13 August 2009  
Project No. 43177672

**Subject: Response to Department of Planning Comments on Proposed Knauf Insulation Glass Wool Manufacturing Facility - Air Quality and Greenhouse Gas Assessment**

This letter provides a response to adequacy review comments of the Proposed Knauf Insulation (KI) Glass Wool Manufacturing Facility - Air Quality and Greenhouse Gas Assessments prepared by URS (2009). Specifically, the letter report is set out in the following manner:

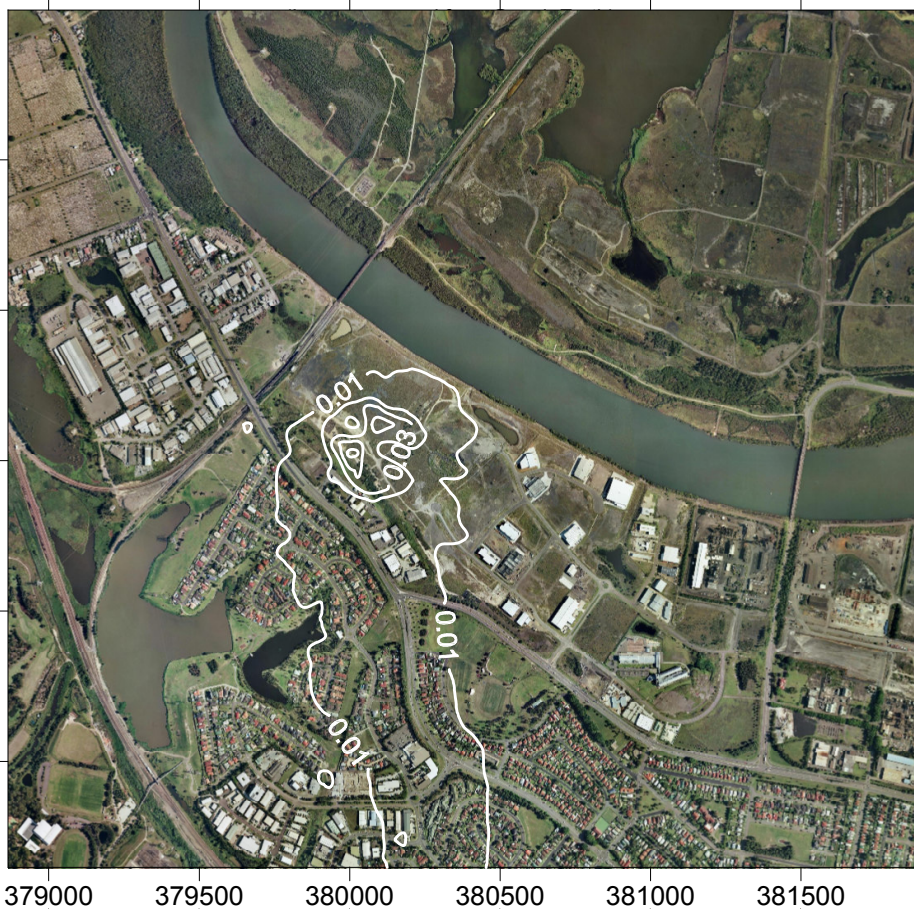
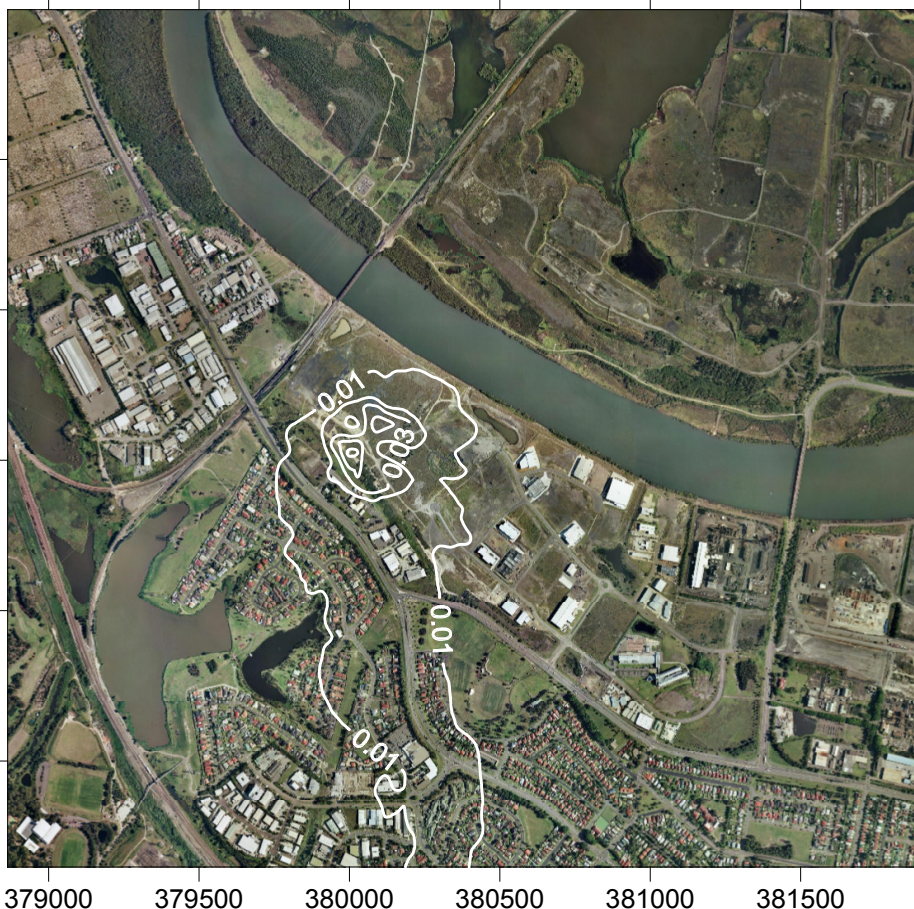
The odour modelling was re-performed using an increased stack height of the Blowing Wool Stack and a reduction in odour concentration from the Wet EP on the basis that downstream processes are not operational during emergency scenarios (including routine maintenance of the Dry EP).

Specifically the Blowing Wool Stack was elevated to 55m (from 40m) and emissions from the Wet EP were reduced by 90% given the cessation of downstream operations during emergency scenarios. All other modelling parameters remained the same, including the conservative assumption that odour emissions from the Emergency Stack and Blowing Wool Stack were emitting odour that occurs at full production rates. The peak odour concentration predicted to occur anywhere within the modelled domain, which includes the area covered by residential receptors, was 1.8 ou during normal operation and 2.4 ou during the emergency scenario. However, the peak odour concentrations of 2.4 ou during the emergency scenario was confined to site and only odour concentrations less than 2 ou were predicted off site. Consequently, it is considered that the odour impact resulting from the plant is below the odour performance criterion of 2 ou. Contour plots are provided in the Figures Section (Revised Figure 2-6).
